**Sent:** 10 February 2026 15:08  
**To:** William Simcock; DC Admin  
**Subject:** DOCO comments for application 2026/90077 at land at Yew Tree Road/Burn Road, Birchencliffe, Huddersfield, HD2 2EQ

Re: 2026/90077- Discharge of details reserved by conditions 2 (materials), 4 (footway), 8 (temporary waste), 9 (bin storage arrangements), and 11 (boundary treatment) on previous permission 2021/91933 for reserved matters application pursuant to outline permission 2018/90776 for erection of 10 dwellings at land at Yew Tree Road/Burn Road, Birchencliffe, Huddersfield, HD2 2EQ

Drawing Title	Boundary Treatments Plan		
Site	Yew Tree Rd (West), Birchcliffe		
Scale	1:500 @A2	Date	10/06/25
Drawn	VB/MC	Checked	MC/BB
Drawing No.	Z234.008	Rev.	-
Thorpe Arch Grange Walton Road Thorp Arch LS23 7BA 01937 543599 www.newetthomes.co.uk

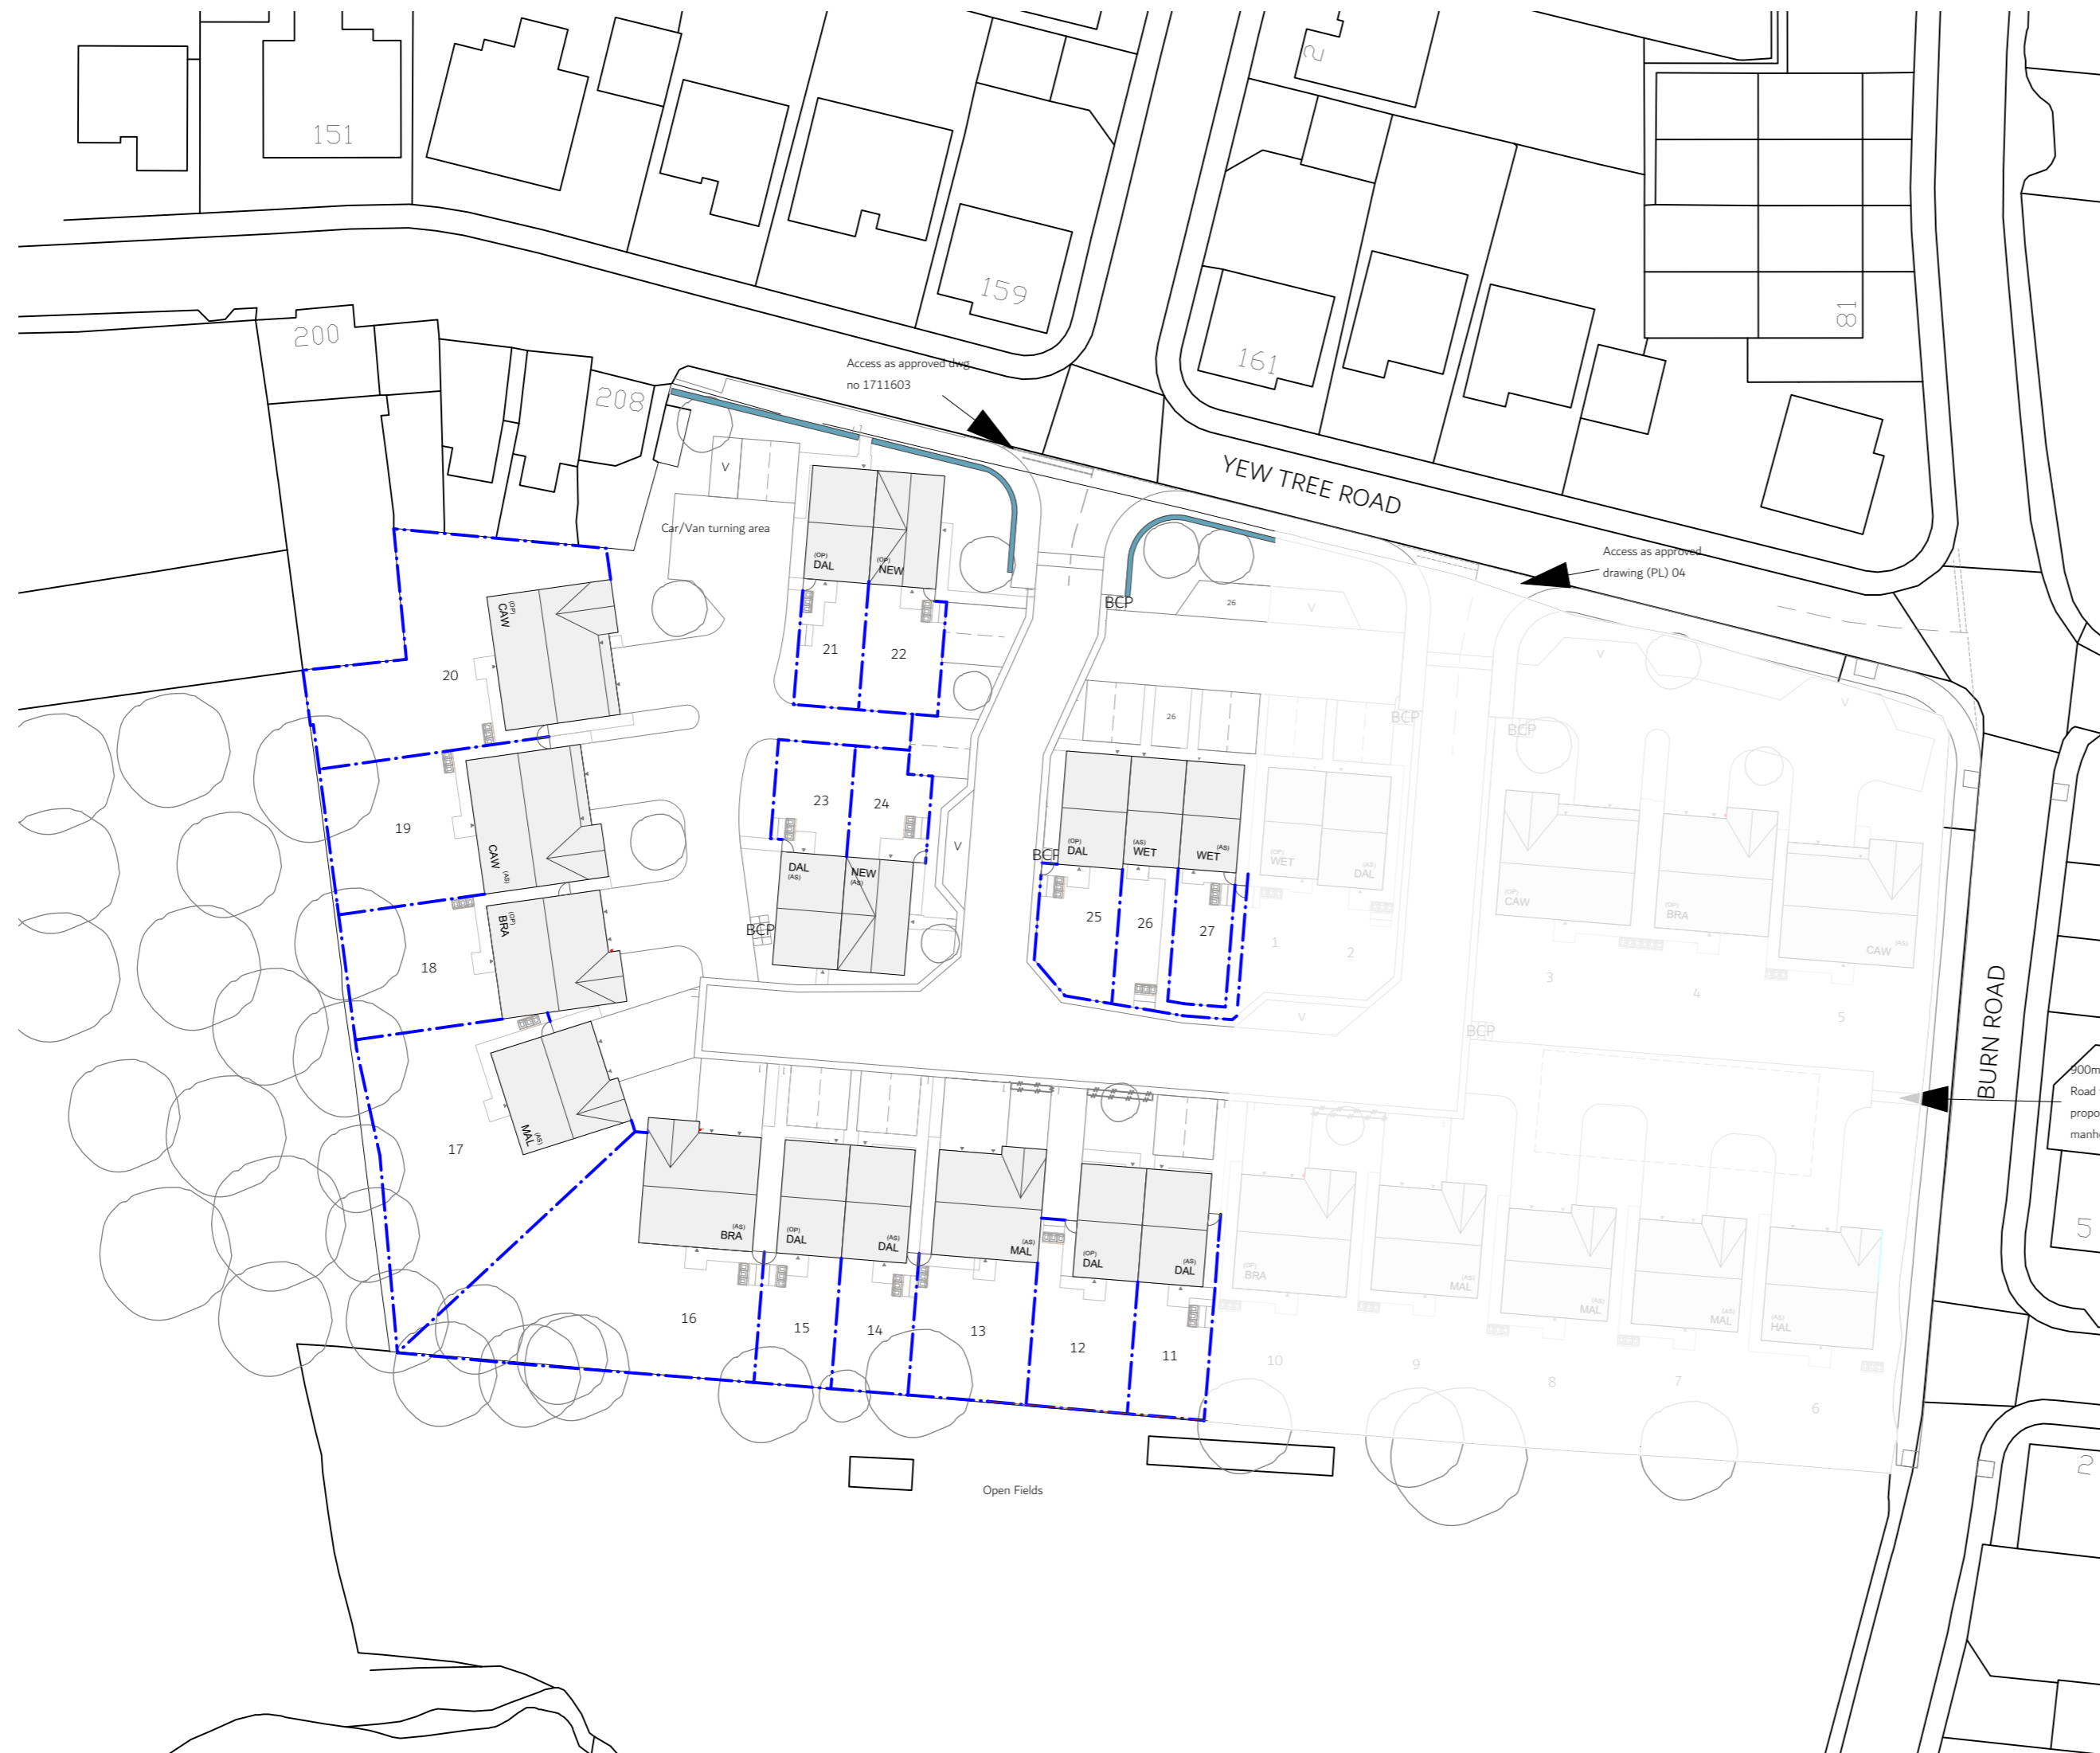
I have reviewed the submitted plan (Z234.008 dated 10/06/25)- it appears to relate to the Western parcel of the development (17 dwellings) rather than the Eastern parcel (10 dwellings). Boundary treatments for plots 11-27 are acceptable. However, I cannot comment on boundary treatments for plots 1-10 as no up-to-date plan appears to have been submitted with this DoC application.
